**WEST SUSSEX COUNTY COUNCIL
STRATEGIC PLANNING CONSULTATION**

SUBJECT: FP/230/11 - Erection of 1 x 2-bedroom house.

Side of, Ivy Cottage, 42, Flansham Lane, Felpham, West Sussex

Proposed Site Plan 1:500

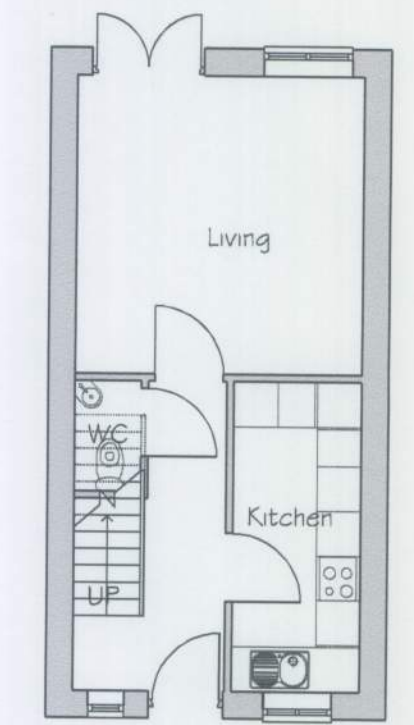
A single space parking provision is proposed and this will be located to the west of Ivy Cottage making use of the existing access arrangements of the former Ivy Cottage Nursery. The former Ivy Cottage Nursery has approval for a 29 dwelling development under planning application FP/115/11, which would also use this access point. We would not consider that a single extra dwelling making use of this access to be significant enough to cause a highway safety concern. From inspection of the plans, it would appear that a turn on site would be possible. There appears to be no apparent visibility issue at the point of access onto Flansham Lane. I have also checked the most recently available verified accident records, which reveals there have been no personal injury accidents in the vicinity of the existing point of access.

I can confirm that the level of vehicular parking provision is considered appropriate for a development of this size in this location, even when taking into consideration the parking provision for Ivy Cottage itself. I would ask that cycle parking be included in this proposal due to its sustainable location. This provision should be a suitable size to store at least one cycle and be secured and covered. The actual details of the cycle parking facilities should be submitted to and approved by the Local Planning Authority (LPA)

If the LPA are minded to approve this application conditions securing the parking and cycle parking should be included.
